From: Martyn White
Sent: 20 June 2019 11:28
To: Planning.Responses
Cc: Zac Denton
Subject: LU/140/19/L

LU/140/19/L

The application relates to the front balcony at 15 South Terrace. This property is a listed building, and it sits within a conservation area (Littlehampton Sea Front). It is a late C18/early C19 terraced house; 3 storey, with attic and basement with area. The neighbouring properties are also listed buildings.

Proposed Front Elevation
(1:100)

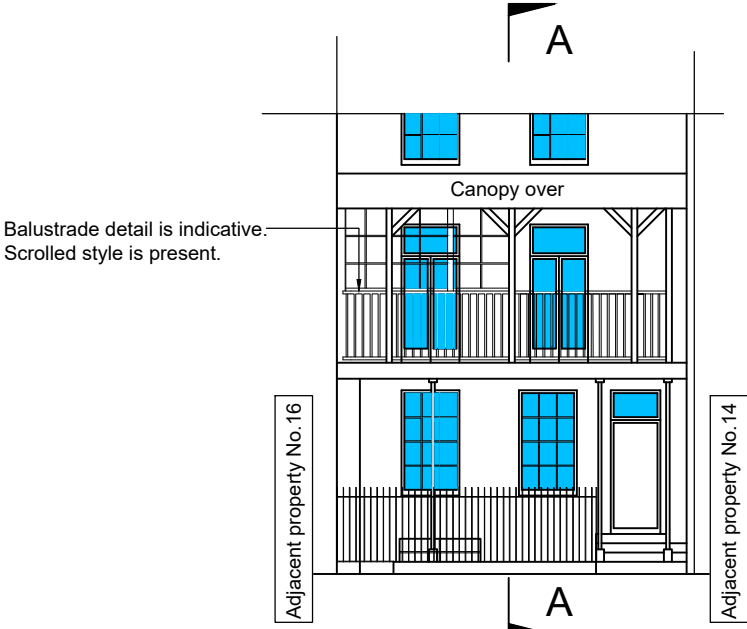
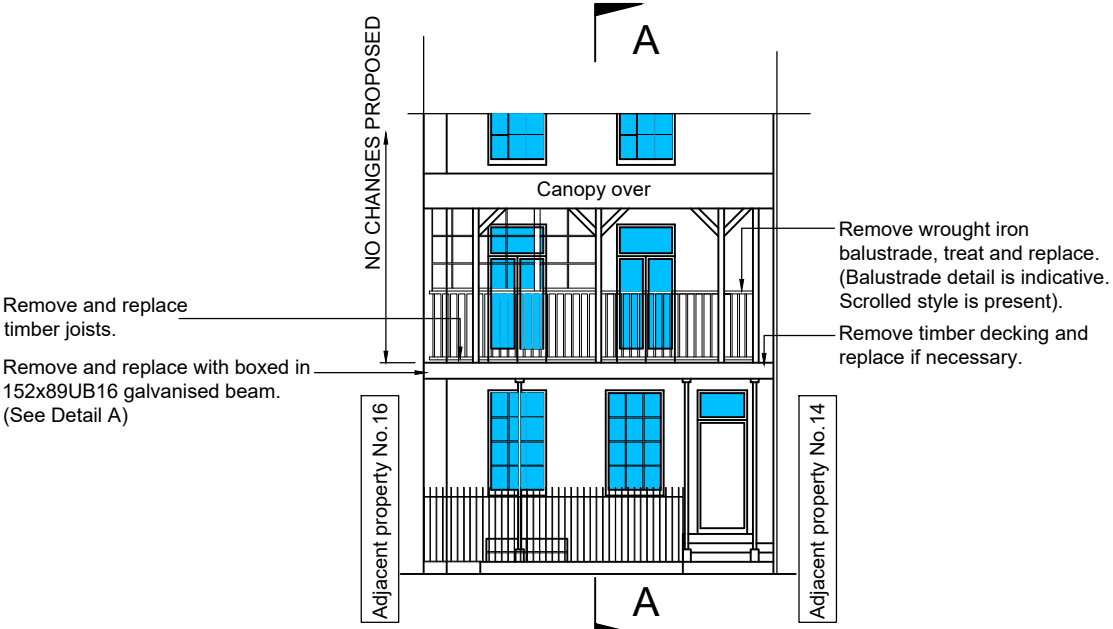
The proposed works essentially amount to a like for like replacement of the balcony. The only difference that I can identify is the fact that a galvanised steel beam (which will be clad in wood), will replace an existing wooden one.
